Recommendation Report for Lawful Development Certificate for a Proposed Use or Development

REF NO: AW/144/22/CLP

LOCATION: 10 Aldwick Place
Aldwick
PO21 4AD

PROPOSAL: Lawful development certificate for a proposed first floor extension over existing entrance hall.

drawing no. no. 10 - 004

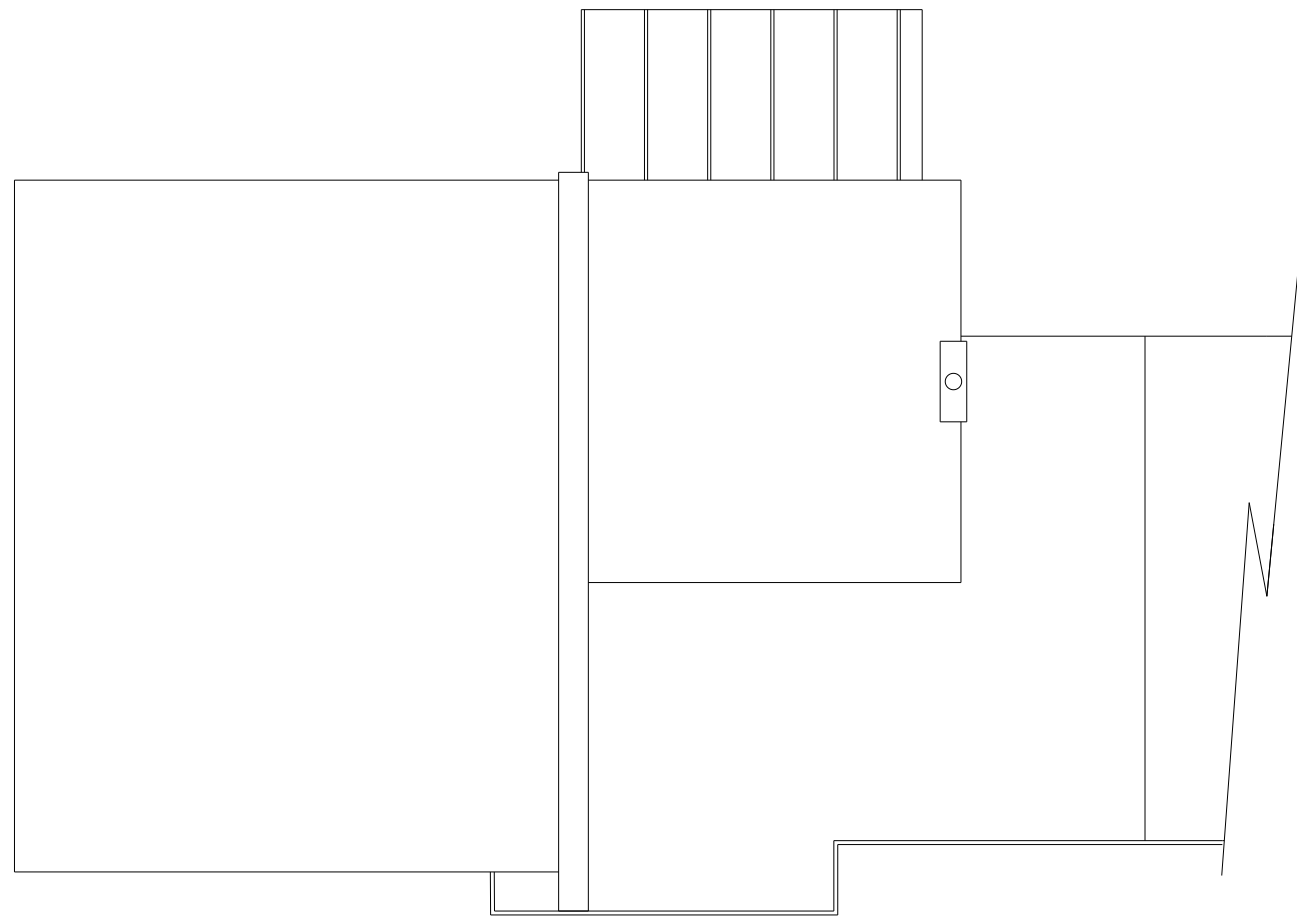
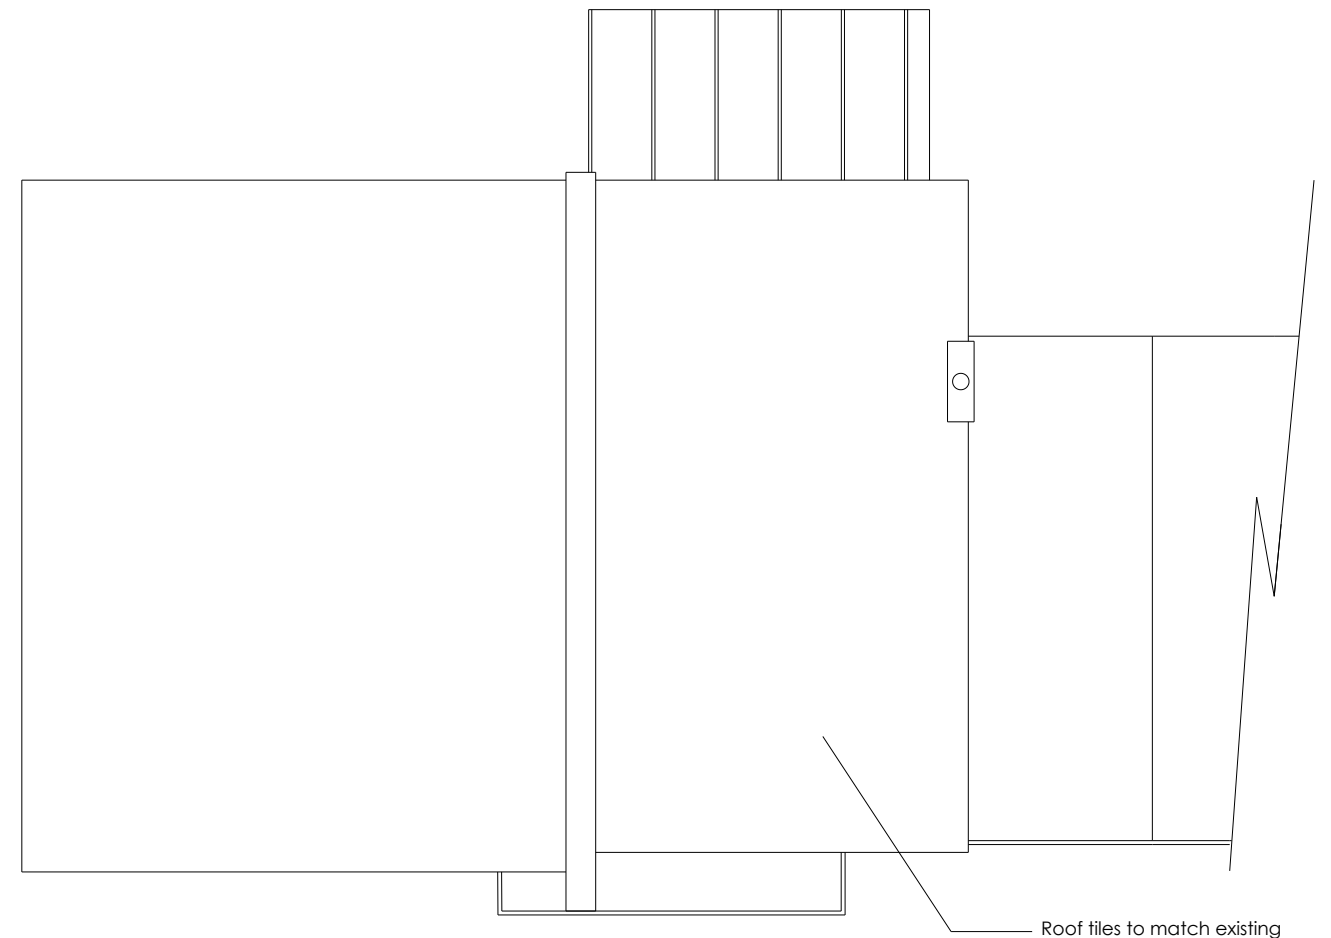
Secondly, the proposal conflicts with B.1(c) any part of the dwellinghouse would, as a result of the works, extend beyond the plane of any existing roof slope which forms the principal elevation of the dwellinghouse and fronts a highway. The guidance states 'The effect of this is that dormer windows as part of a loft conversion, or any other enlargement of the roof space, are not permitted development on a principal elevation that fronts a highway and will therefore require an application for planning permission'.

The guidance notes 'The enlarged part of the roof must not extend beyond the outer face of any wall of the original house if it is to qualify as permitted development, unless it joins the original roof to the roof of a rear or side extension', which in this case it is to the front elevation.

An application for planning permission should be submitted.

Proposed Elevations
drawing no. no. 10 - 003
date

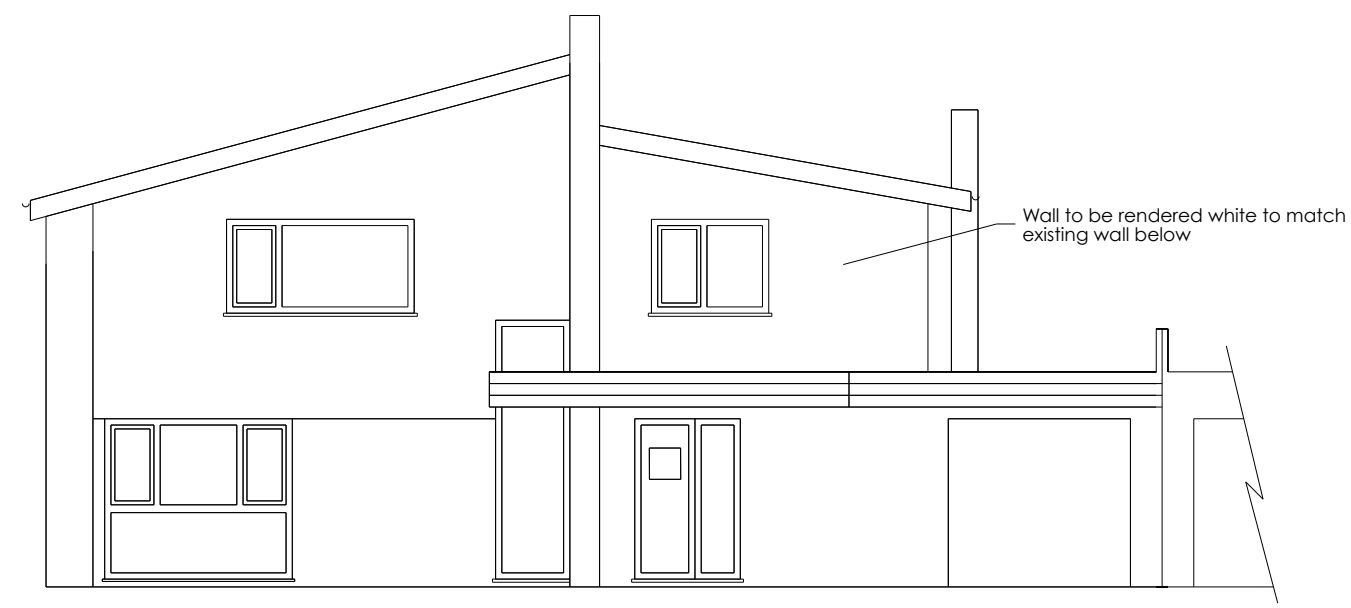
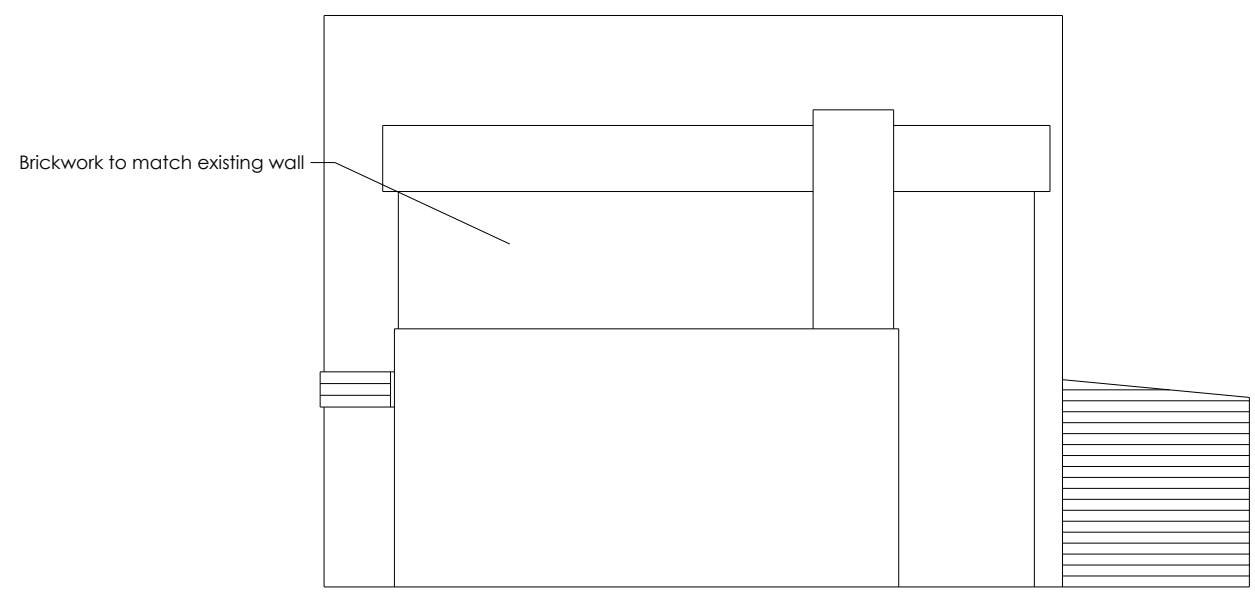
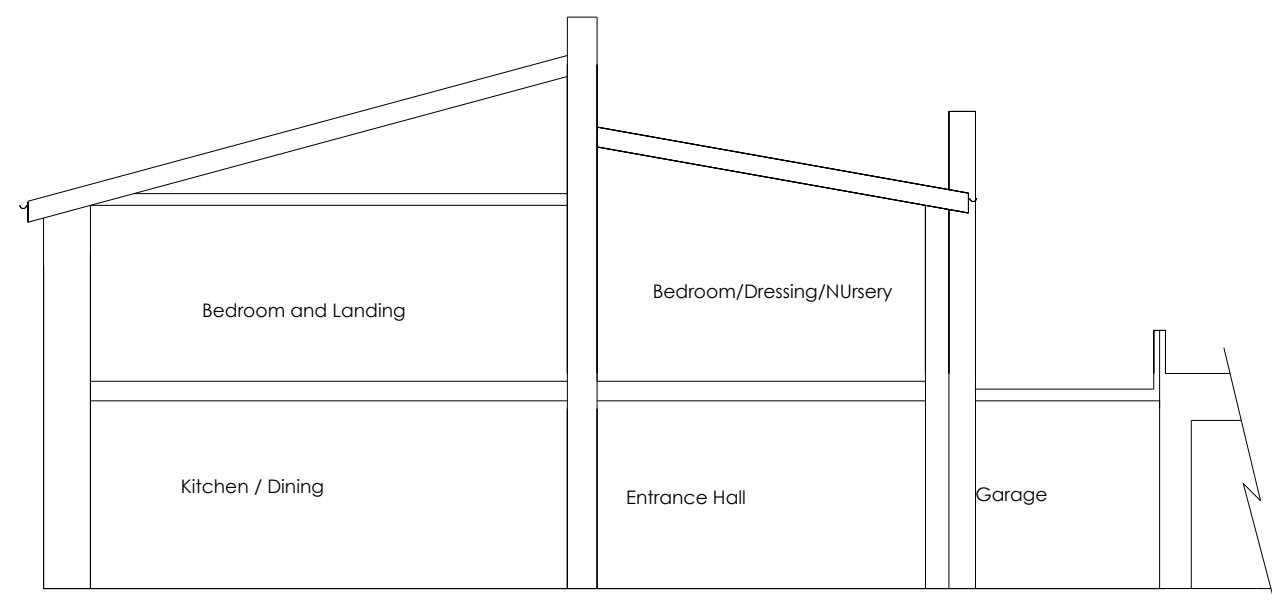
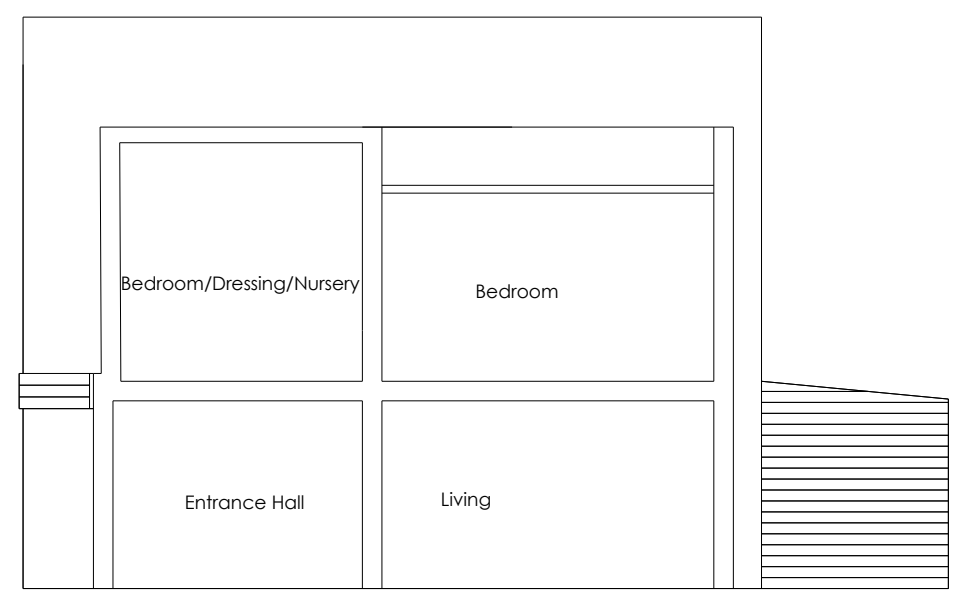
The extension would use white render which matches the ground floor of the house although does not match the existing materials used to the first floor/roof and therefore the materials are not similar and it conflicts with the criteria.

The addition extends beyond the upper wall forming the principal elevation and fronts a highway.
